**UTS Central, Broadway Precinct (SSD 7382)  
Notice of Exhibition**

TfNSW comments on the development are provided below:

Phase 1

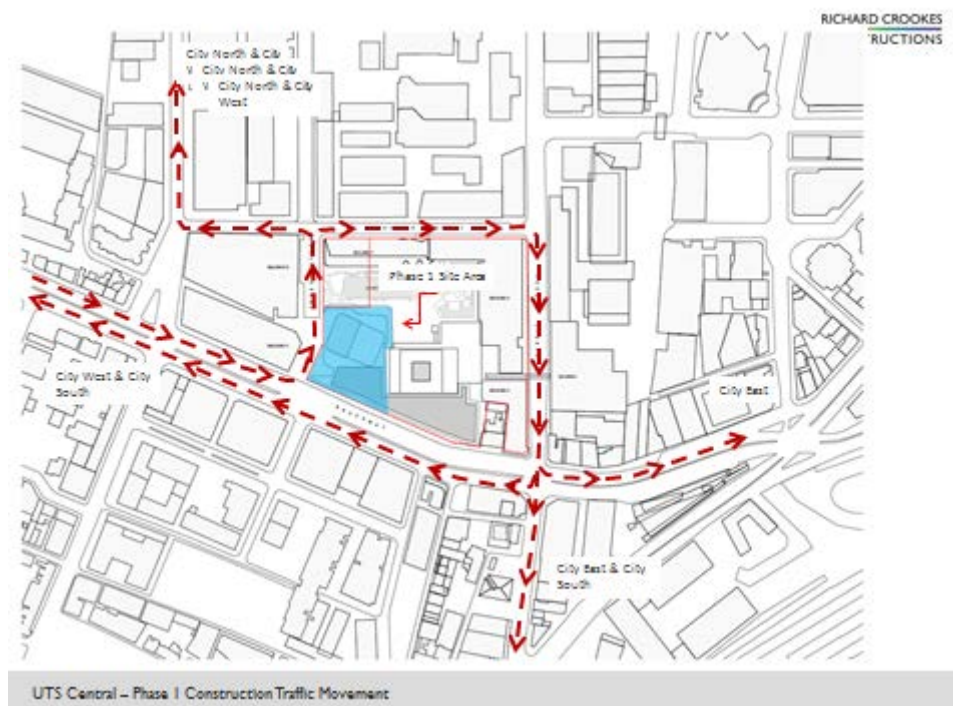
The Construction Traffic Management Plan (CTMP) proposes to reopen Jones Street to left in movements to allow access to the phase one construction site. Due to this arrangement, vehicles accessing the site may impact on bus services operating along Broadway, which is a key bus corridor into and out of the CBD. TfNSW requests that the applicant work with the CBD Coordination Office and RMS to determine appropriate access arrangements to the site, which minimise the impact on bus services.

Swept path analysis for all vehicles accessing the construction site should be provided for both phase 1 and phase 2 in the CTMP.

- Swept path analysis for all vehicles accessing the construction site;
  - Consultation strategy for liaison with surrounding stakeholders;
  - Any potential impacts to general traffic, cyclists, pedestrians and bus services within the vicinity of the site from construction vehicles during the construction of the proposed works, including phase 2 of the construction works;

Phase 2

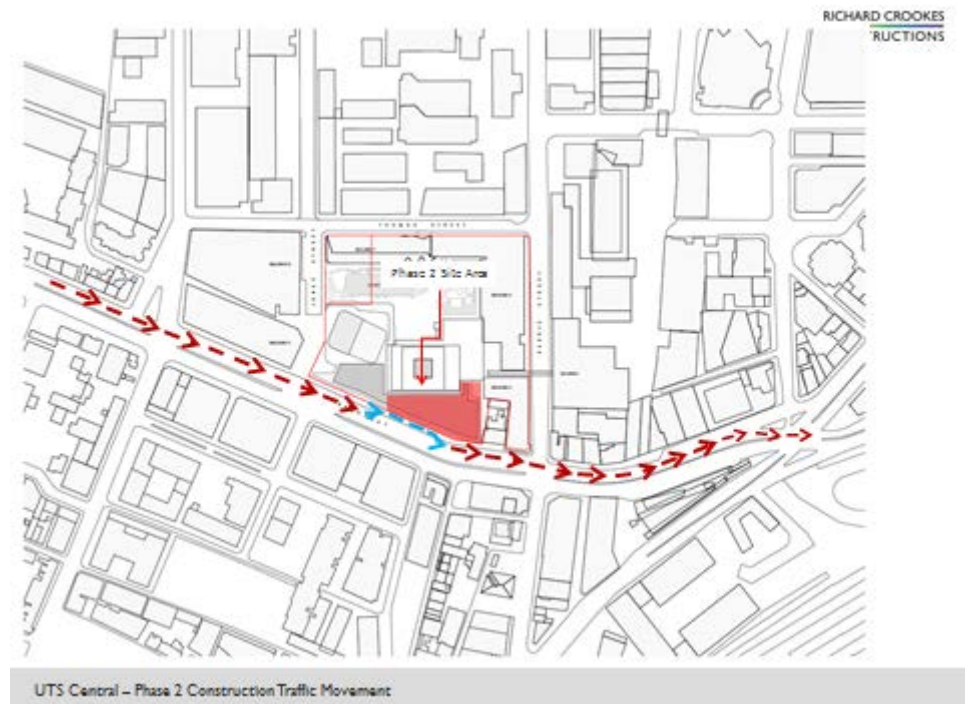
The applicant has provided limited information on the construction details during phase 2 of the works. The utilisation of the existing footpath area and the UTS shuttle bus area in front of Building 1 during phase 2 works is likely to have a significant impact on pedestrians and bus customers. TfNSW requests that further details on the construction management and assessment of the construction staging, access, impact and the development of mitigation measures during the phase 2 works be undertaken.

During stage 6 of the construction works it is estimated that 110 truck movements per day are expected to occur. This may have a significant impact on the operation of the transport network. Further assessment of the impact, including traffic modelling, of the construction vehicles accessing the site should be undertaken and mitigation measure identified. TfNSW requests that safe access for pedestrian and cyclists should be maintained throughout all stages construction.
